COUNTY COUNCIL'S RESPONSE TO CONSULTATION ON THE FOLLOWING DEVELOPMENT PROPOSAL

Application No: 18/00193/REM-3

Proposal: Reserved matters application to 14/02156/OUT - for appearance, landscaping and layout (including the layout of the internal access roads, footpaths and cycleways) for 37 dwellings.

Location: Land South Of Cotefield Business Park, Oxford Road, Bodicote.

Road 3
Horiz. 1:500 Vert. 1:50

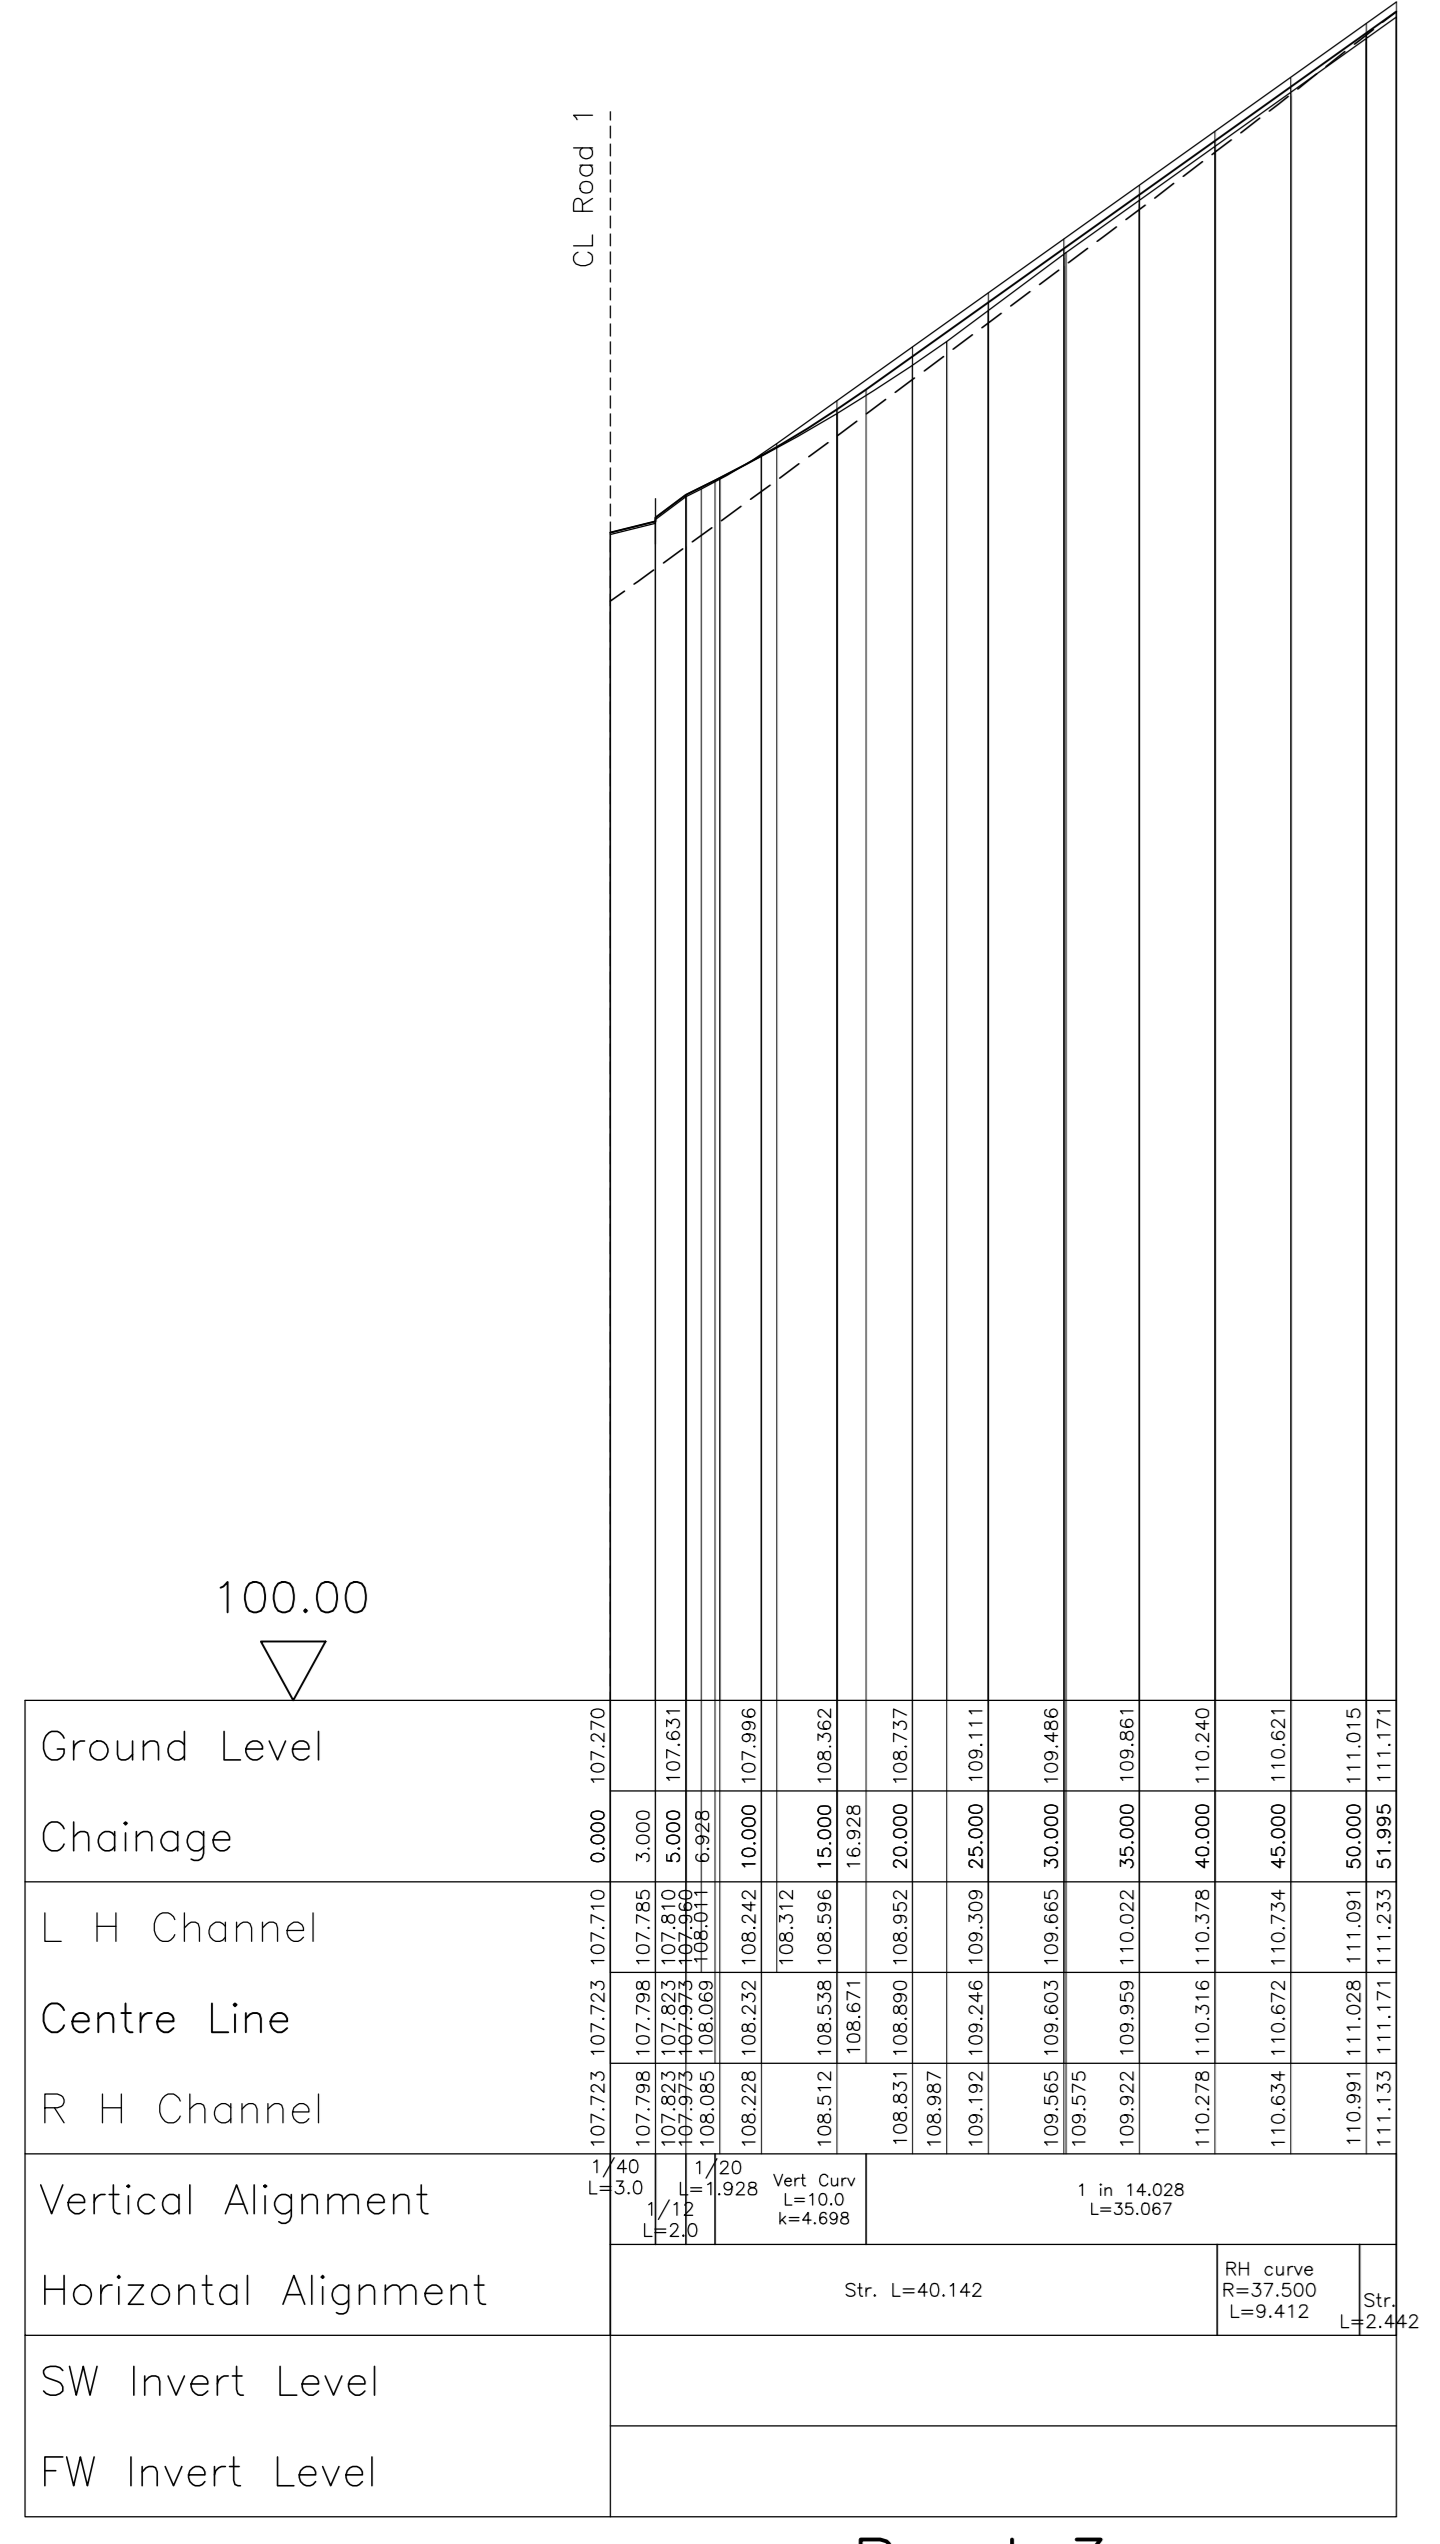
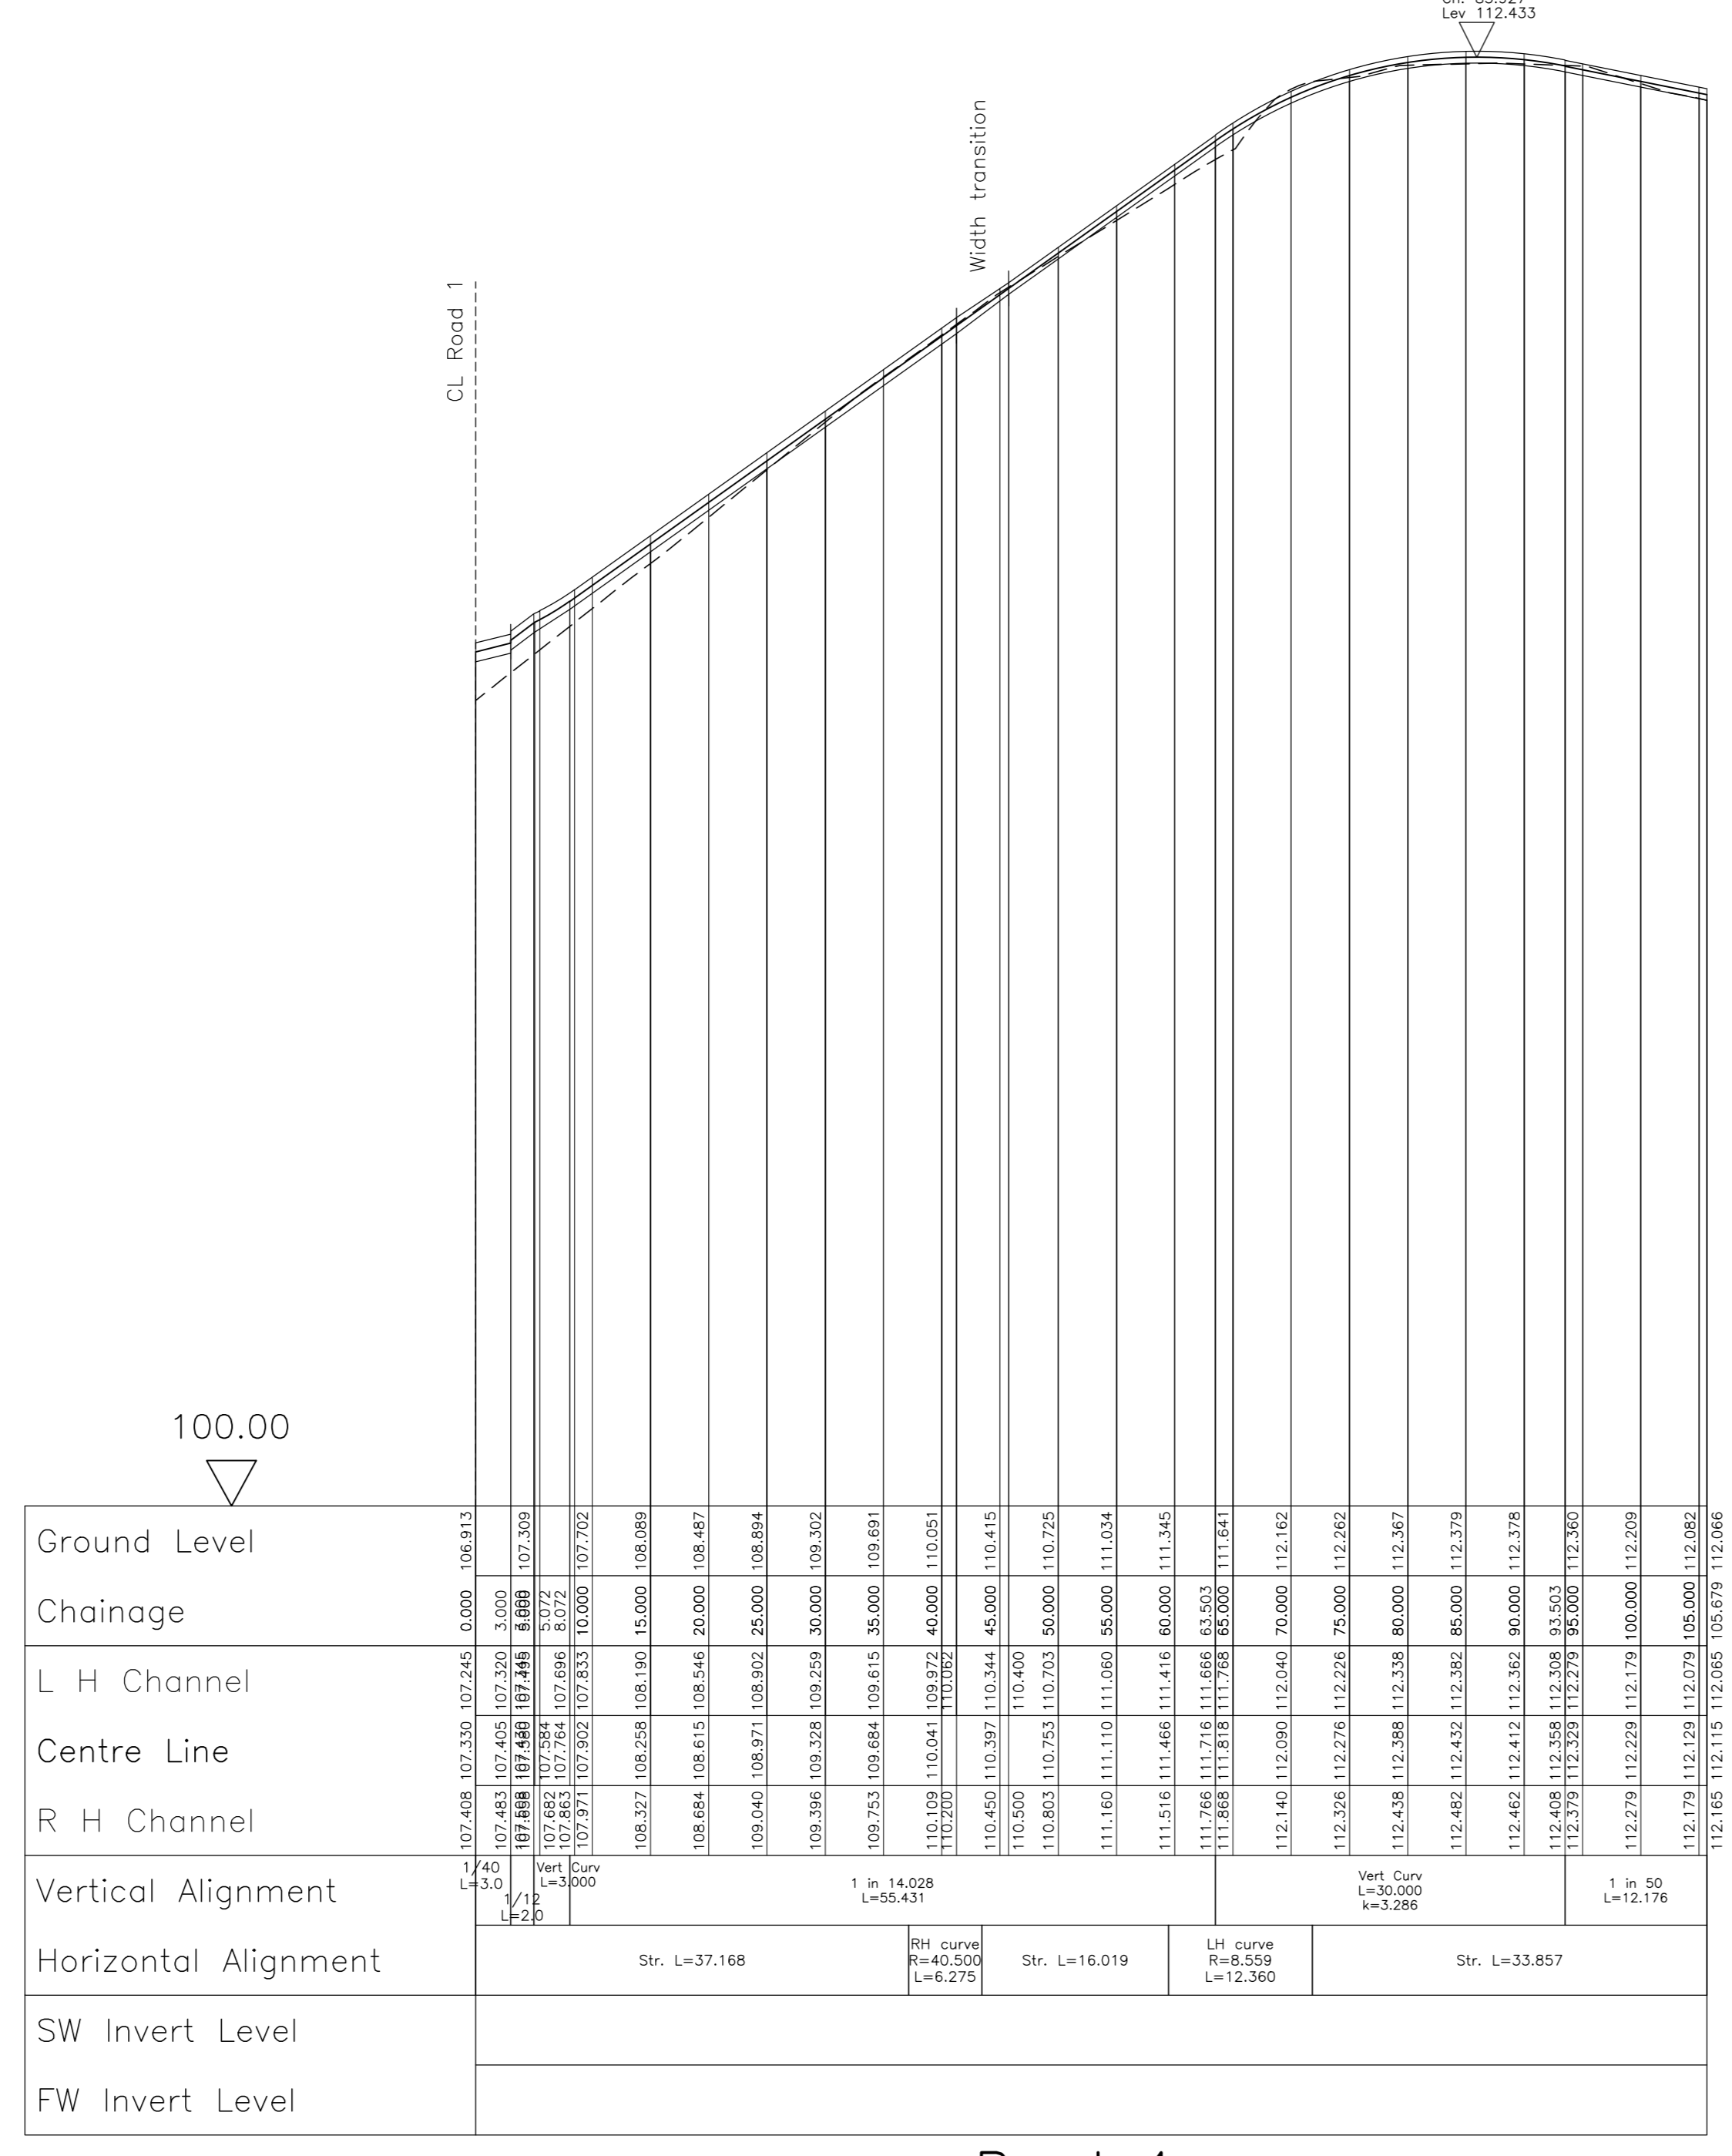
Regarding the proposed levels, 1:12 is the absolute maximum gradient that the Local Highway Authority will accept, and this only over very short lengths of road where it is unavoidable. If the gradient is 1:12 or above over longer stretches of road, this will inhibit access to parts of the development for the elderly, disabled people, and parents with small children or who move pushchairs. Therefore, this is contrary to paragraph 32 of the NPPF and I recommend objection on these grounds.
